## OFFICIAL NOTICE OF DECISION

CITY OF ALBUQUERQUE  
PLANNING DEPARTMENT  
DEVELOPMENT REVIEW BOARD

**Project# 1007316**

11DRB-70284 SITE DEVELOPMENT PLAN FOR BUILDING PERMIT  
11DRB-70303 MINOR - PRELIMINARY/ FINAL PLAT APPROVAL

SITE PLAN - PHASE 2 (FULL BUILD-OUT)
1" = 50'-0"

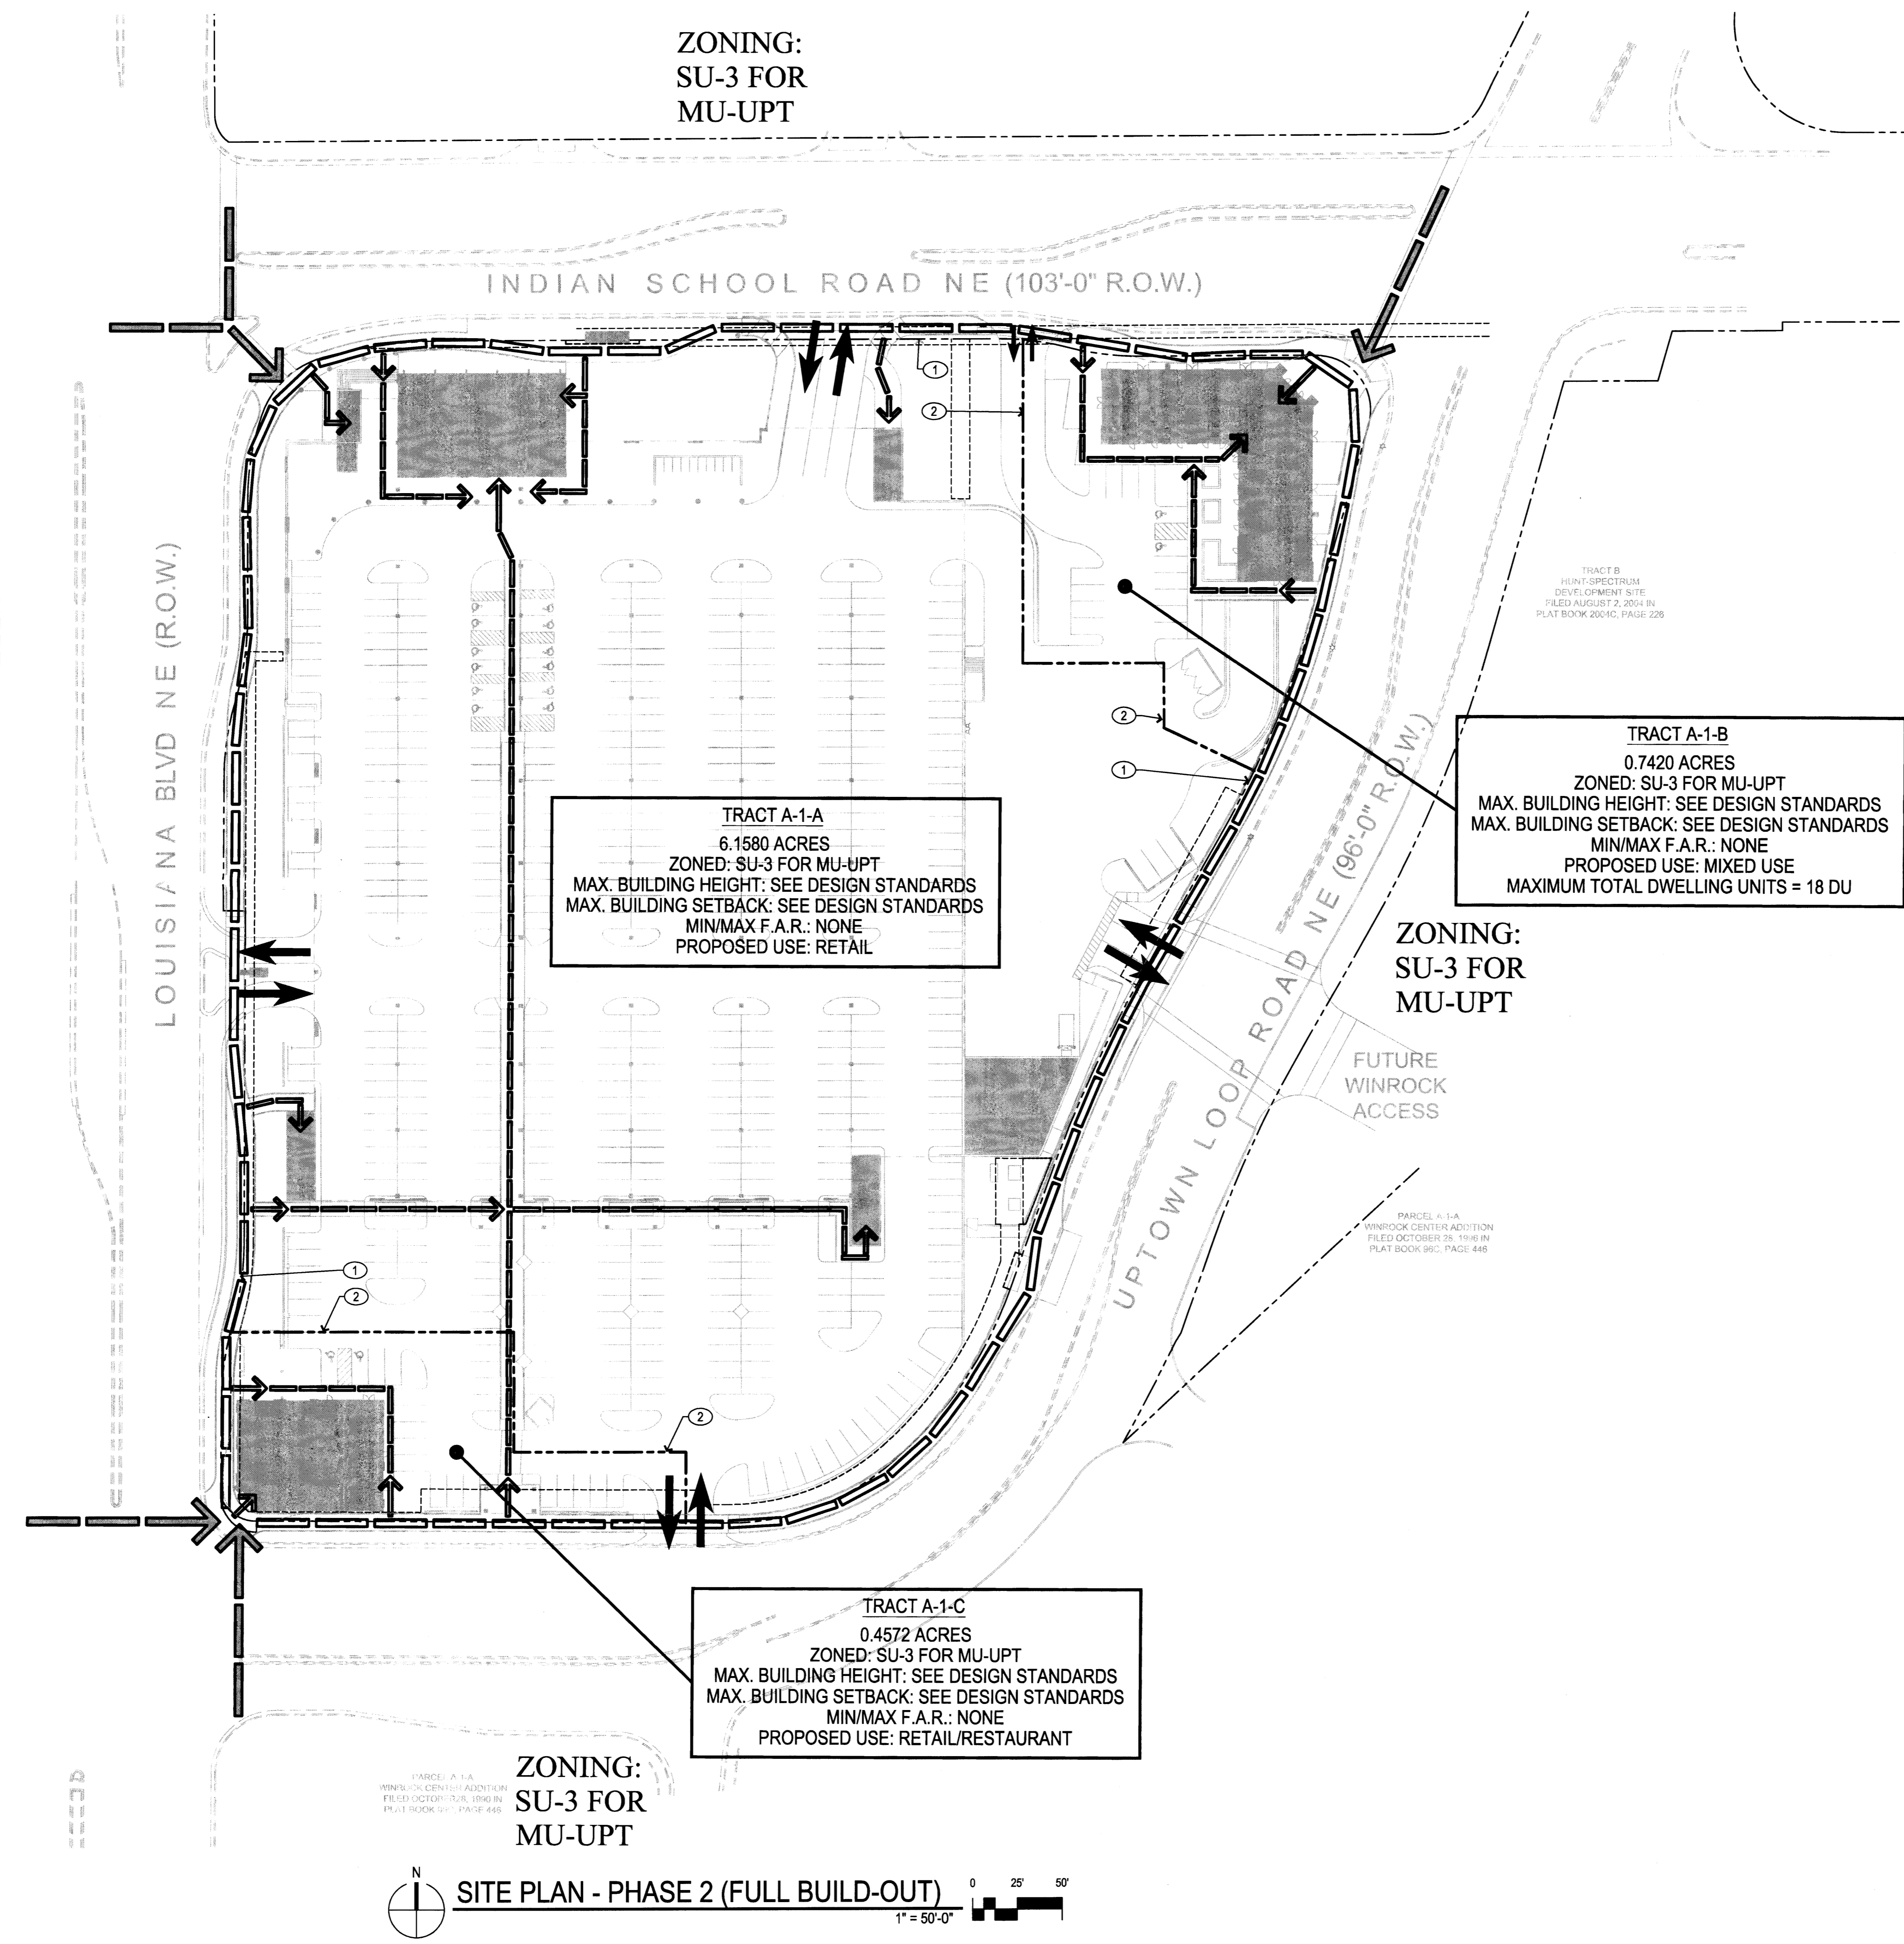
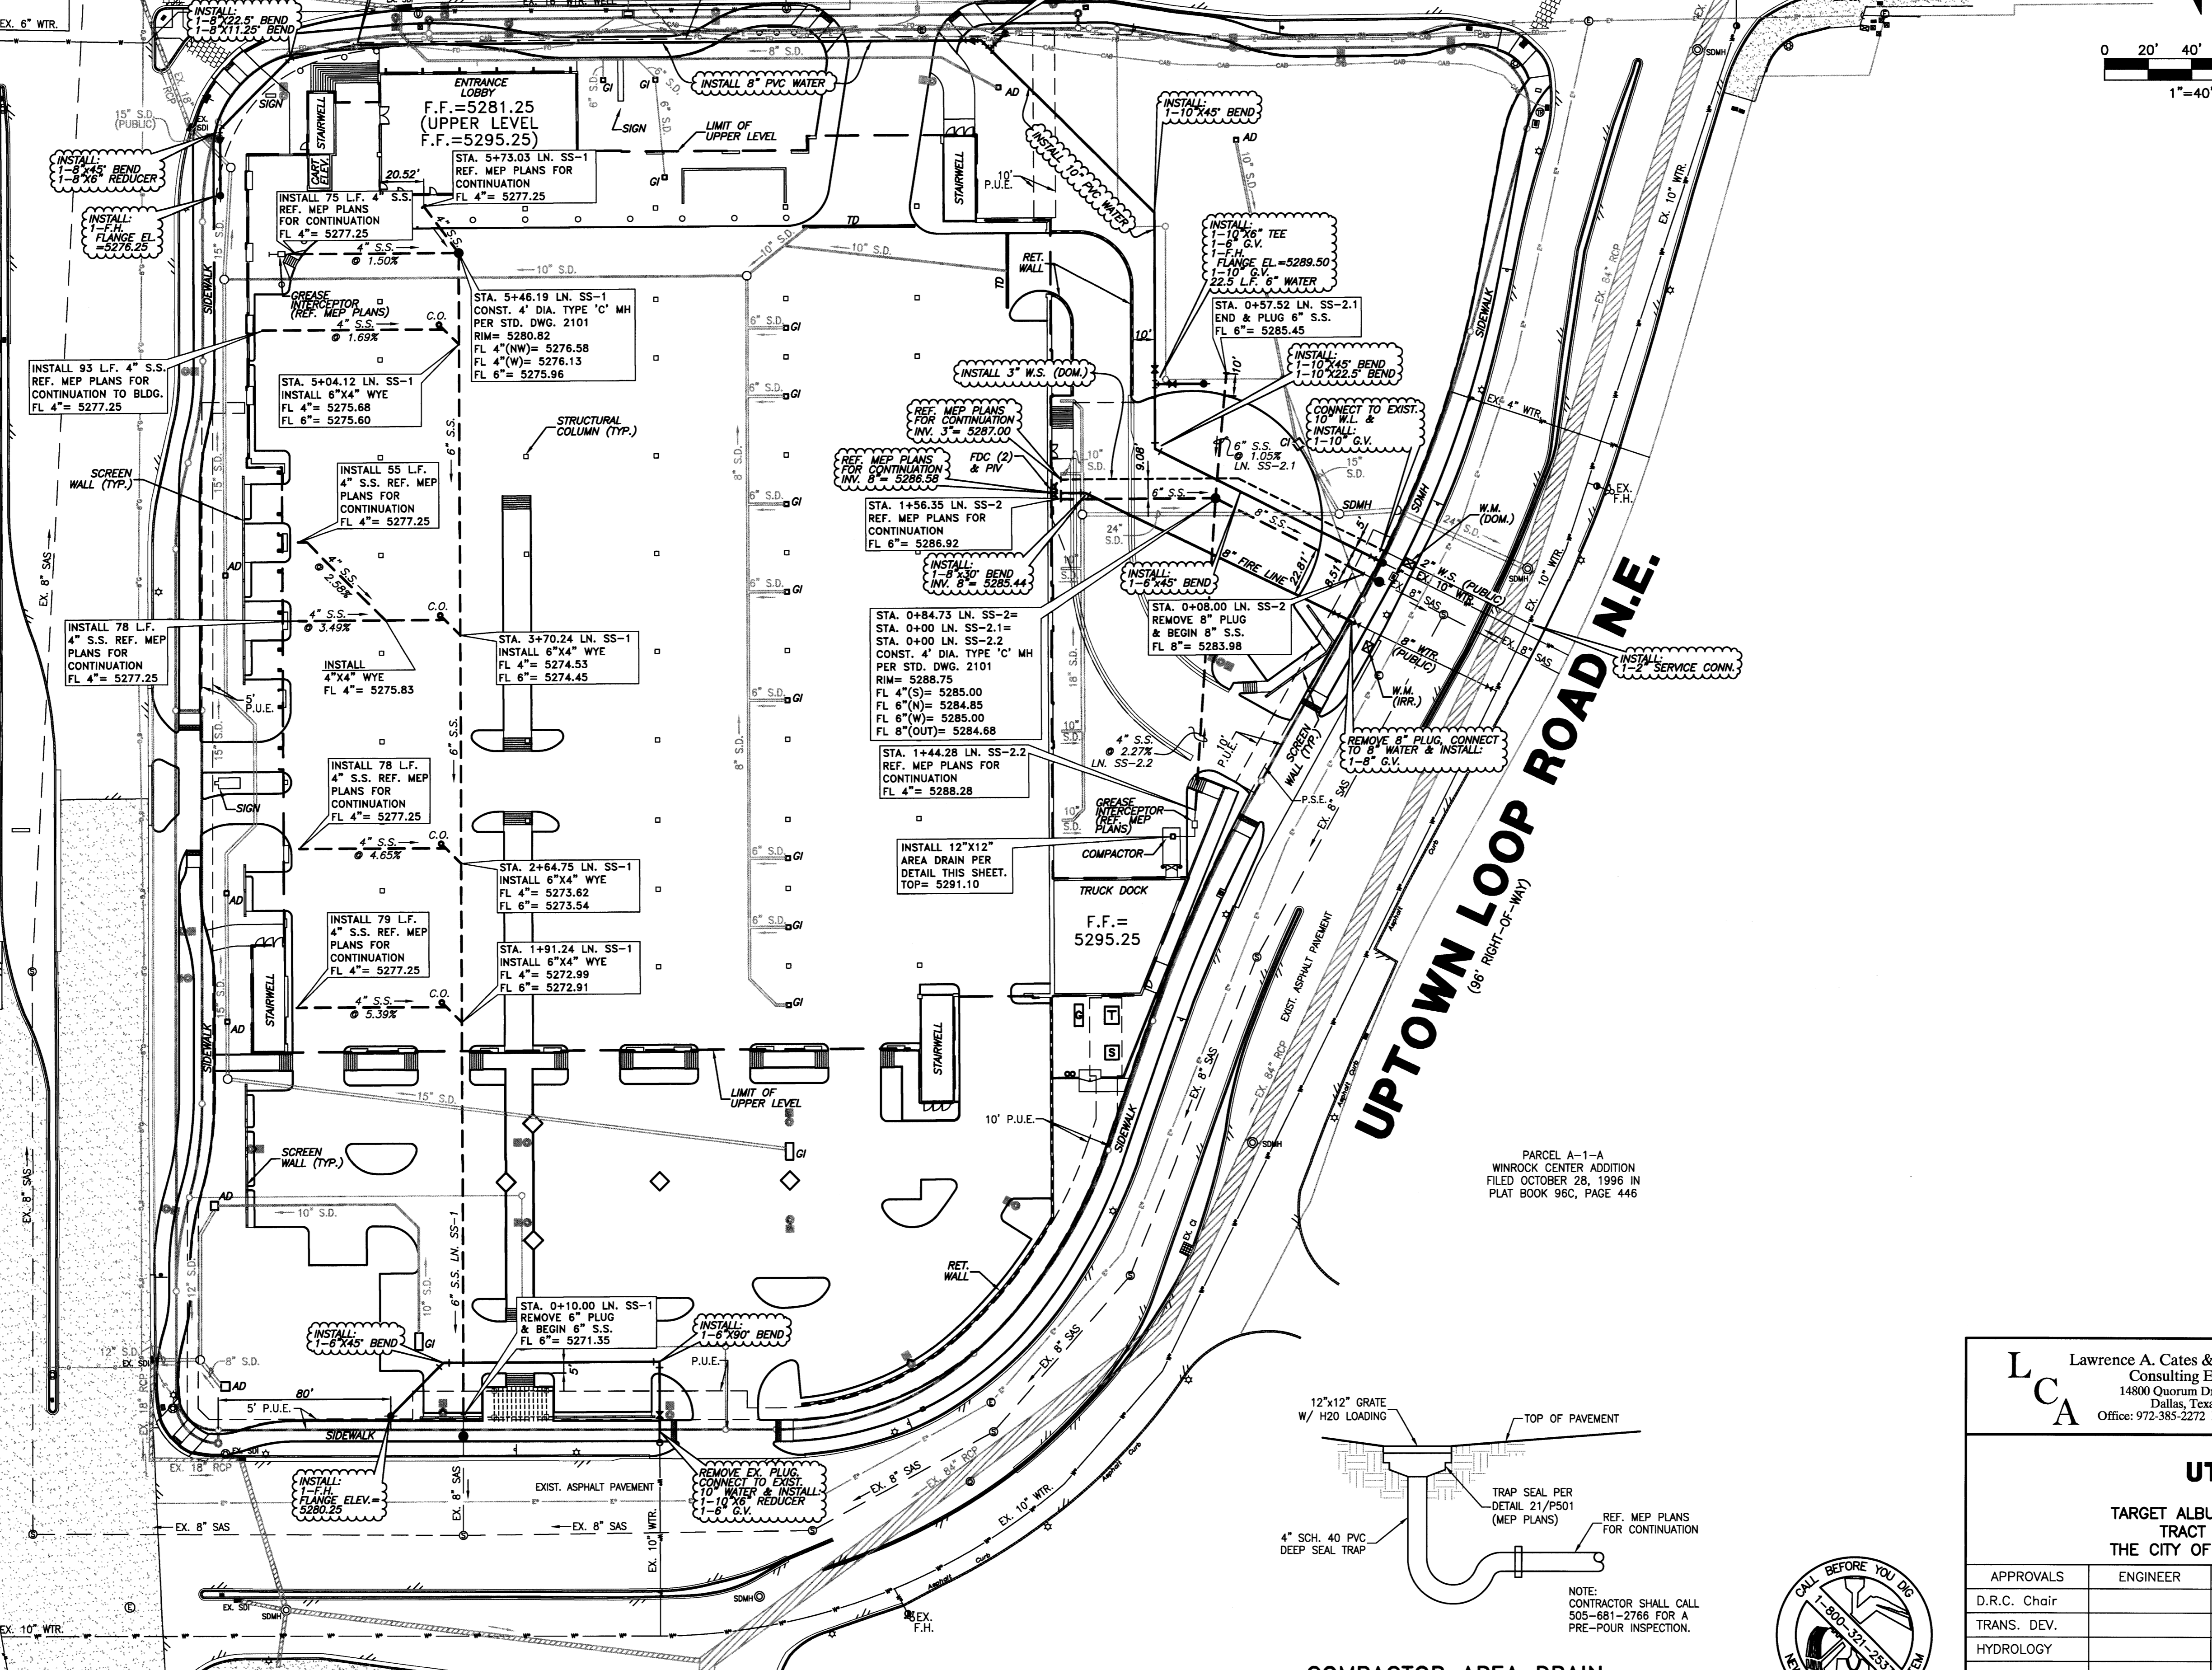
1. The pedestrian linkage in the parking lot on the south of Building 1 shall have a flared/ split concrete connection to the public sidewalk on the Uptown Loop Road, to direct pedestrians west or east.
2. A contrasting color (and/ or material) shall be used as a major façade change over the new vehicular access on the east elevation.
3. An informational note shall be provided regarding care for delivery allocation to minimize semi-trailer conflicts with vehicular customer traffic.
